Your ref
LU/111/21/DOC

Proposal: Approval of details reserved by condition imposed under ref LU/287/17/PL relating to Condition Nos 7 - divert public sewers and 8 - foul & surface water sewerage disposal.

Site: LU/111/21/DOC: - 46a & 47 Pier Road and Land North of Clifton Road, Littlehampton, BN17 5LW.

MIXED USE DEVELOPMENT
46a - 47 PIER ROAD
LITTLEHAMPTON

SCALE	DRAWN BY	CHECKED	DATE
AS SHOWN	RAC	MGC	DEC 2019
DRAWING NUMBER	REVISION		
1174-1001-CIV-30	P2

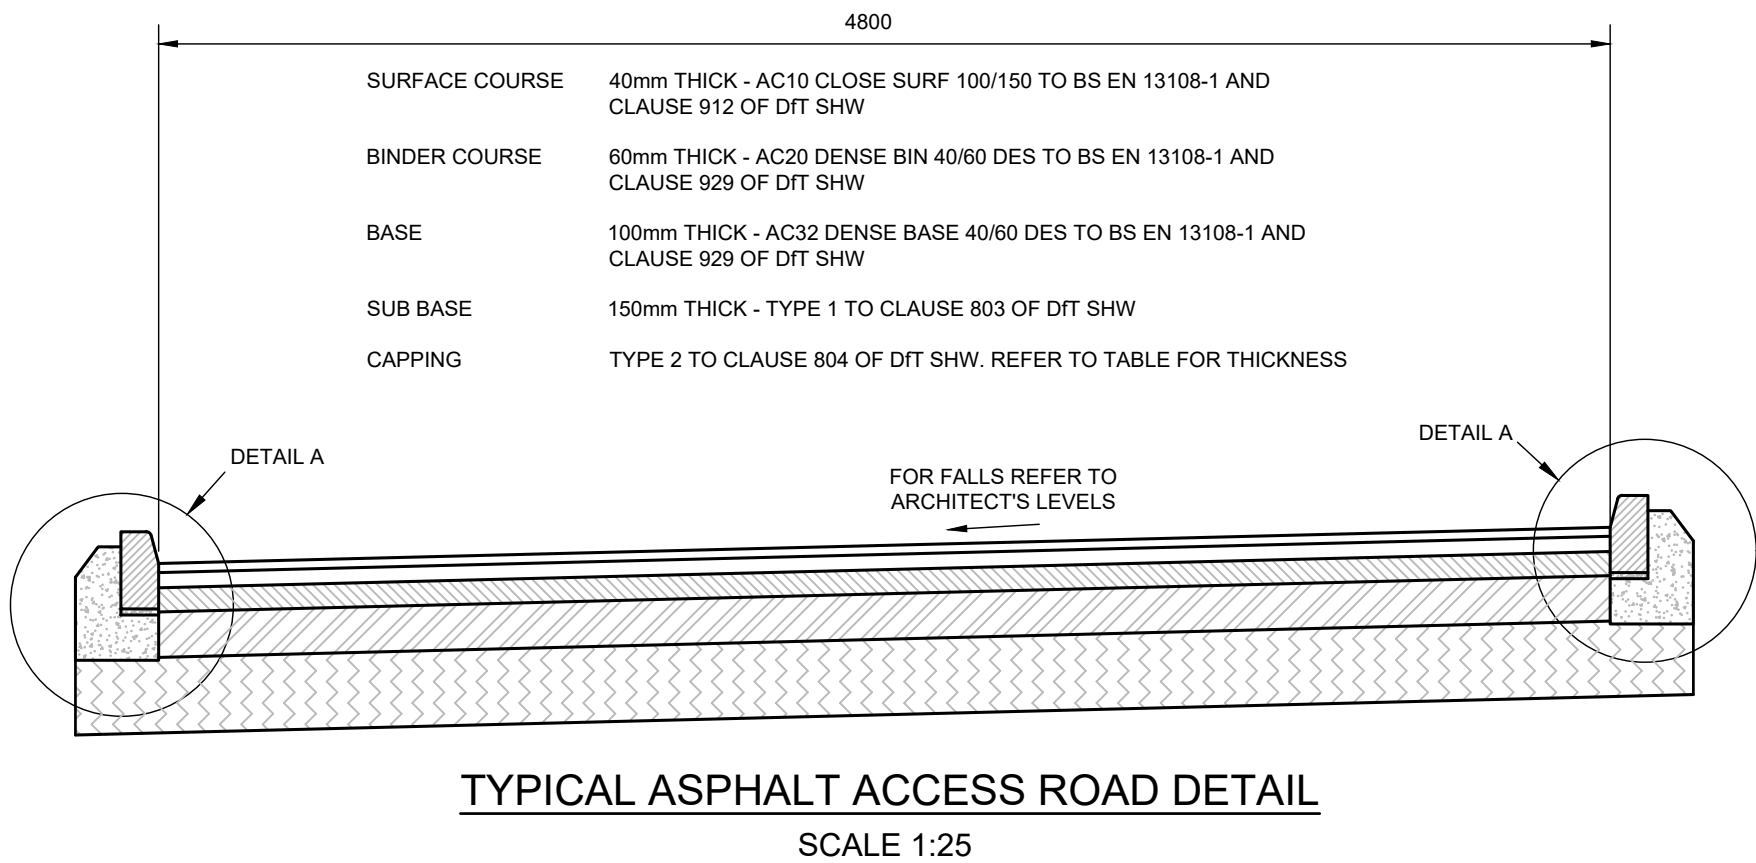
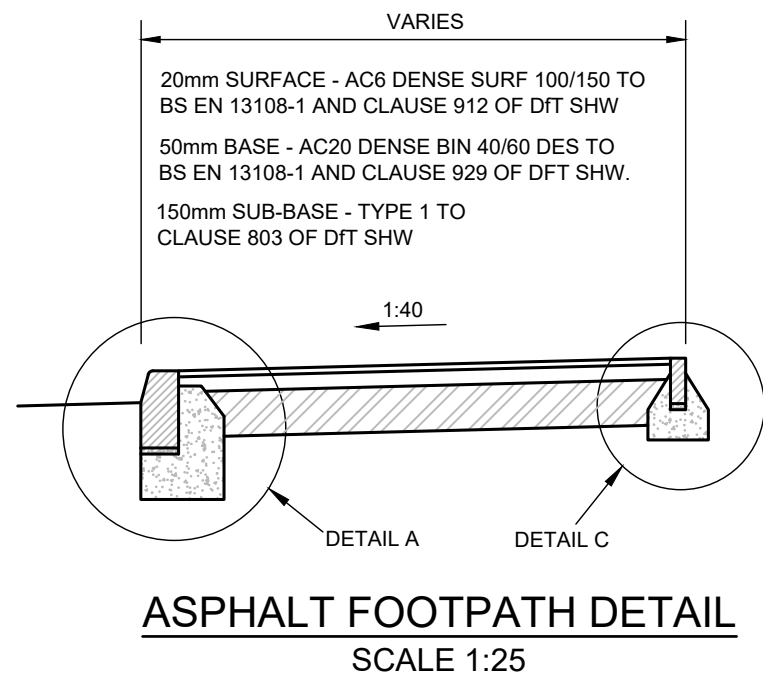
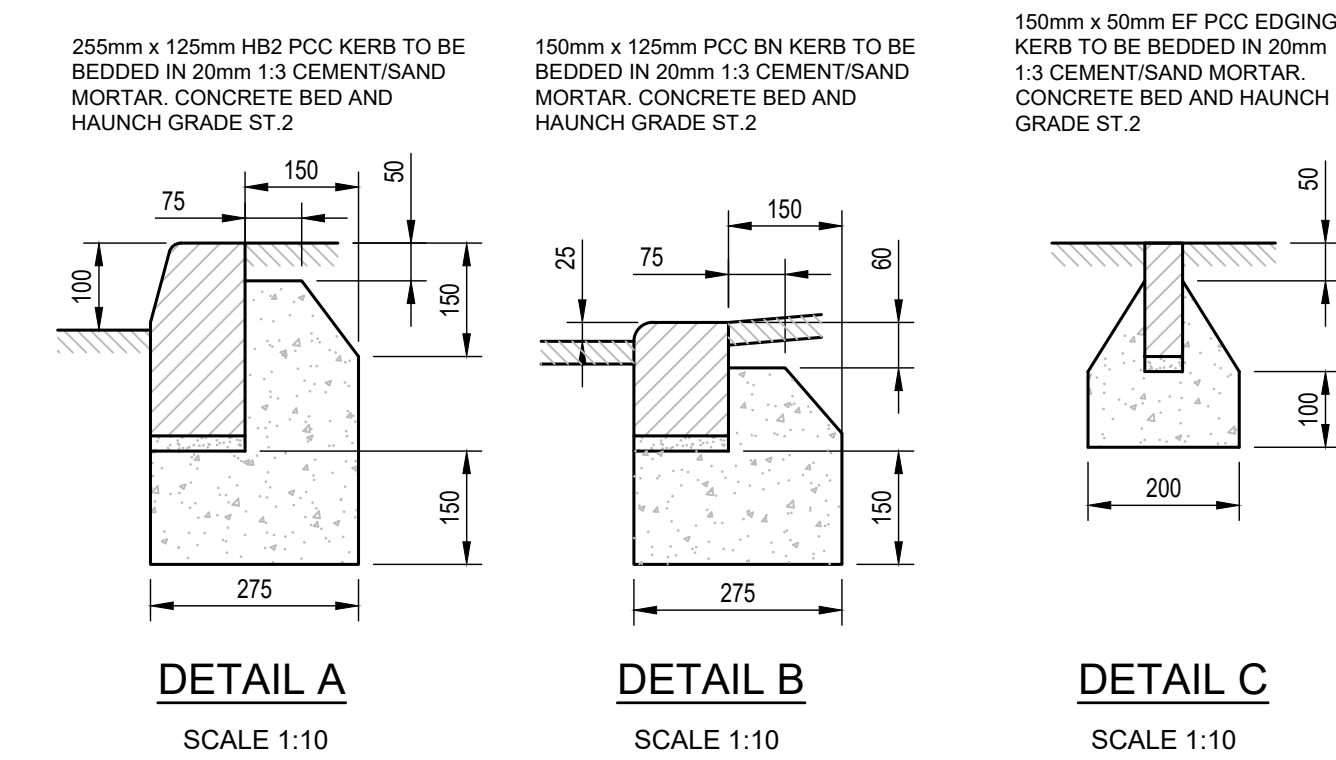
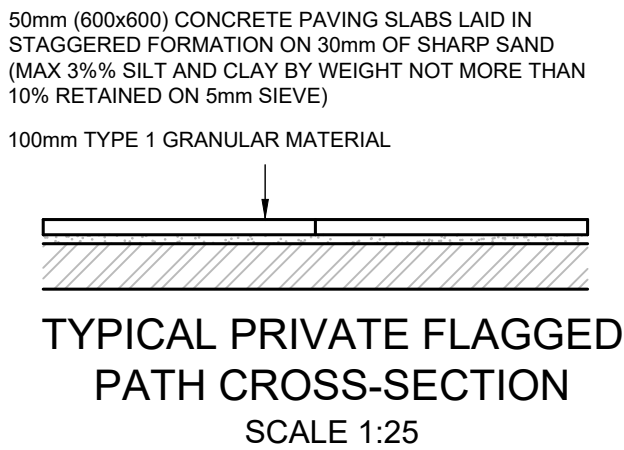
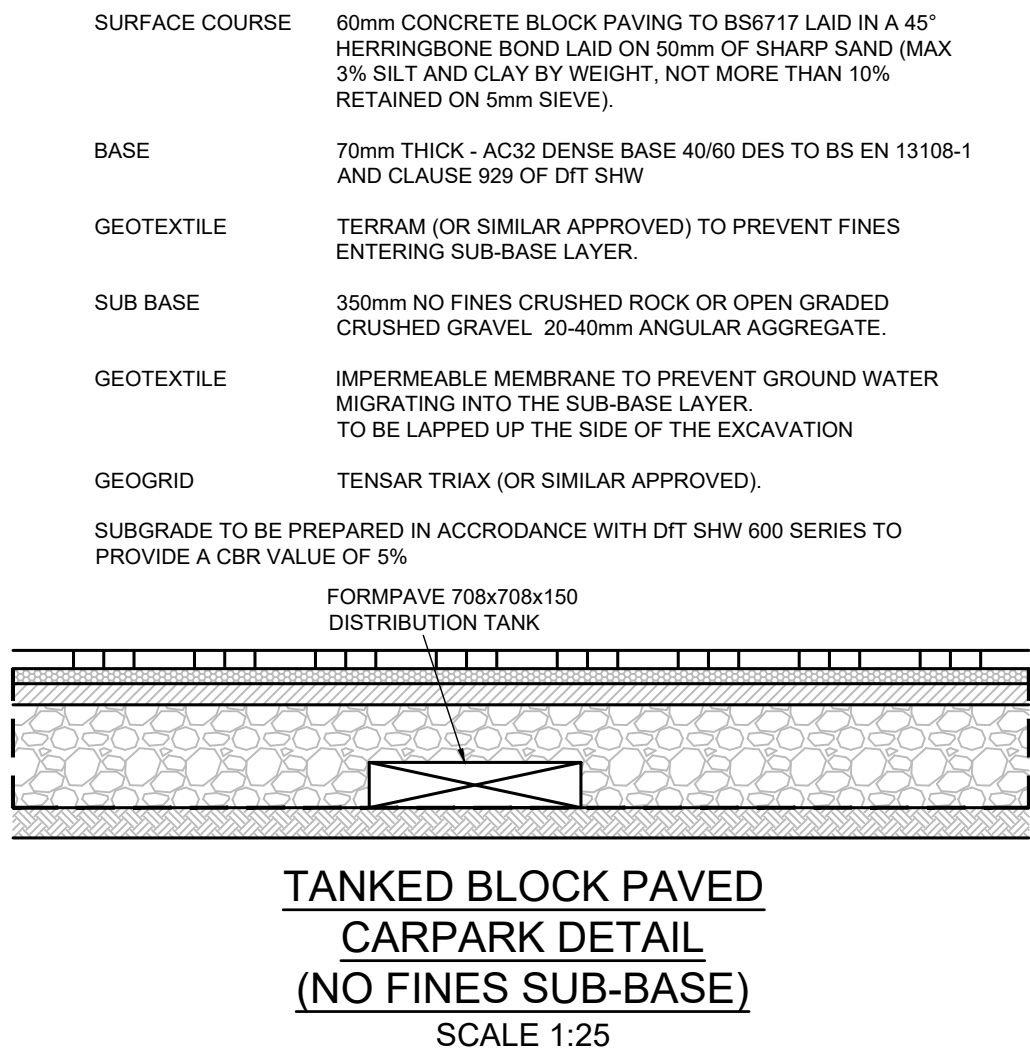
Southern Water cannot recommend discharge of condition 08 relating to surface water drainage. Drainage from the attenuation tank is communicating to the Southern Water public sewerage systems. Please note Attenuation tank should be sealed with impermeable membrane to avoid ingress of ground water. The design of drainage should ensure that no land drainage or groundwater is to enter public sewers network.

Please find attached the amended drawings showing that an impermeable membrane will be constructed at the base of the sub-base storage system to prevent the migration of ground water into the Southern Water sewer. In any event this will be unlikely as the soils are of clay content with poor infiltration characteristics.

P2	POROUS CARPARK DETAIL AMENDED TO TANKED SYSTEM.	20.05.21	MGC
P1	PRELIMINARY ISSUE	10.12.19	MGC
REV	AMENDMENT	DATE	CHKD

1174-1001-CIV-10

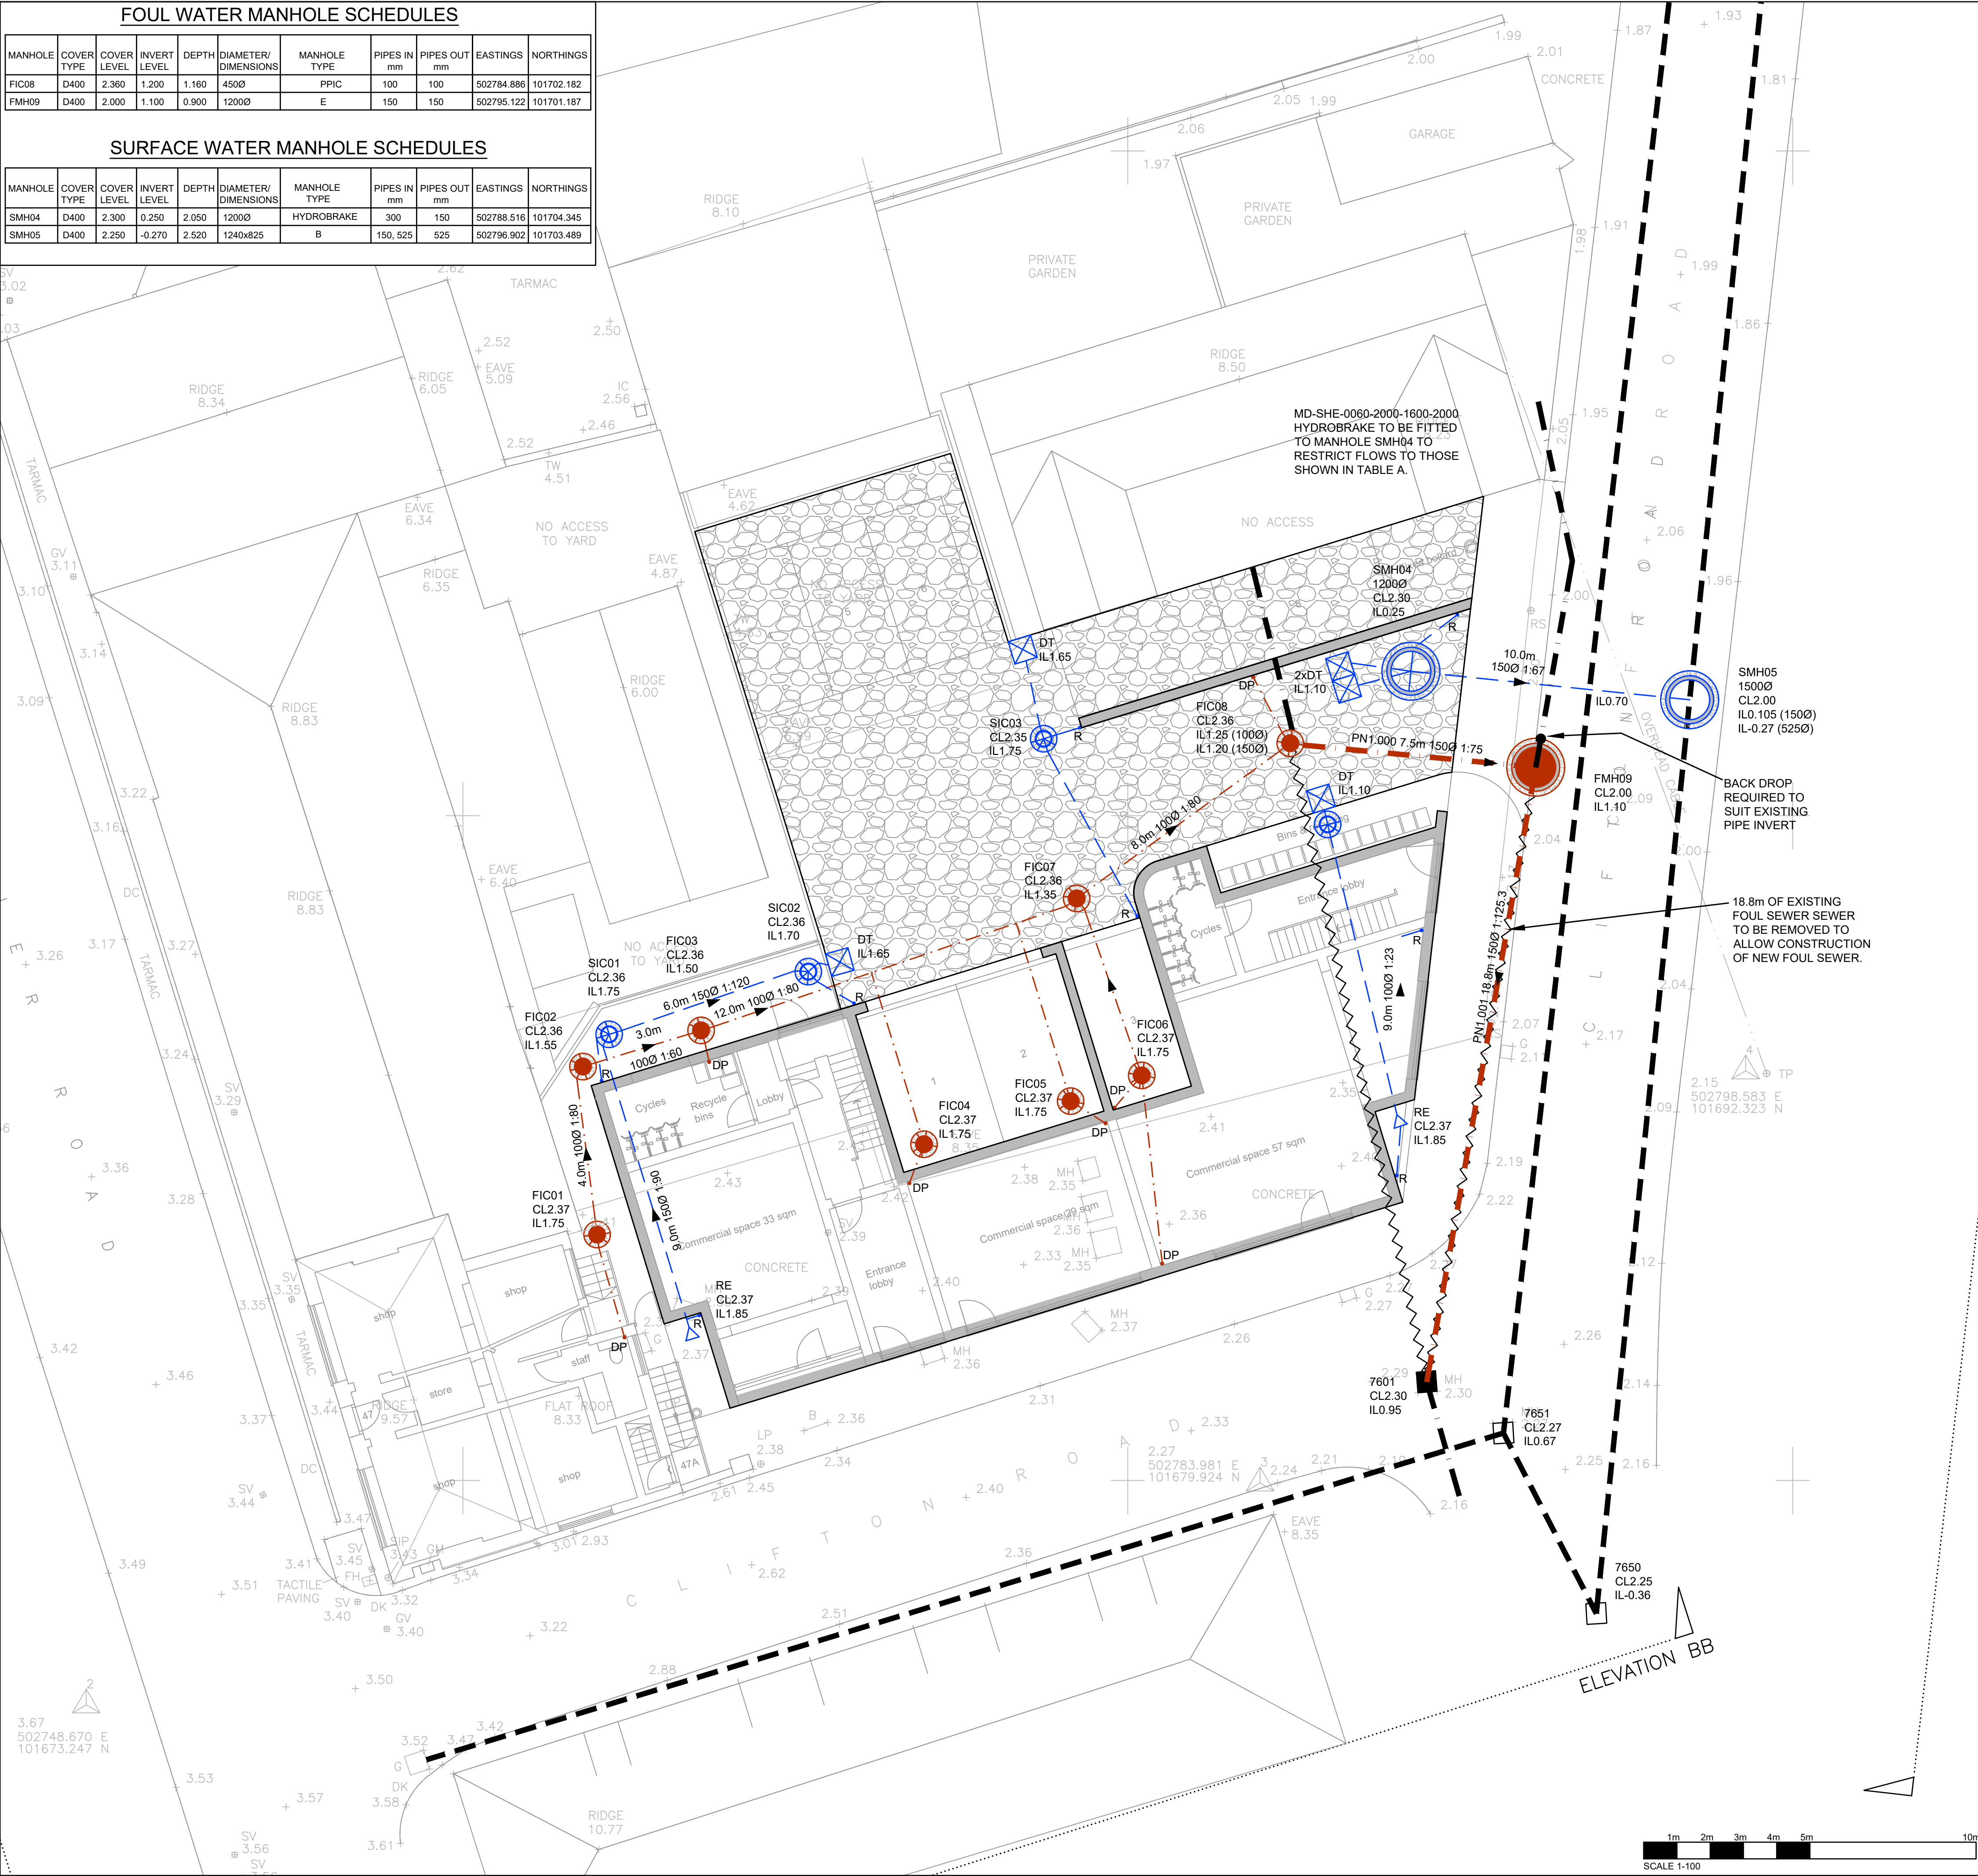
The drainage strategy report demonstrates that the post development surface water flows from the development are reduced from the current flow contributions. Surface water may be discharged to the existing sewer, provided the rate of discharge to sewer is no greater than existing contributing flows.

As you can see from table A on drawing 10 the post-development flow rates are significantly lower than pre-development so all the boxes are now ticked.

17. THE SUB-BASE ATTENUATION LAYER IS TO BE TANKED WITH AN IMPERMEABLE LINER TO PREVENT GROUNDWATER FROM ENTERING THE SYSTEM.

P5	NOTE 17 ADDED AND KEY UPDATED.	20.05.21	MGC
P4	AMENDED TO SUIT SOUTHERN WATER COMMENTS	22.02.21	MGC
P3	DRAINAGE AMENDED TO SUIT LLFA COMMENTS	15.01.21	MGC
P2	MANHOLE SCHEDULES ADDED	10.12.19	MGC
P1	PRELIMINARY ISSUE	04.12.19	MGC
REV	AMENDMENT	DATE	CHKD
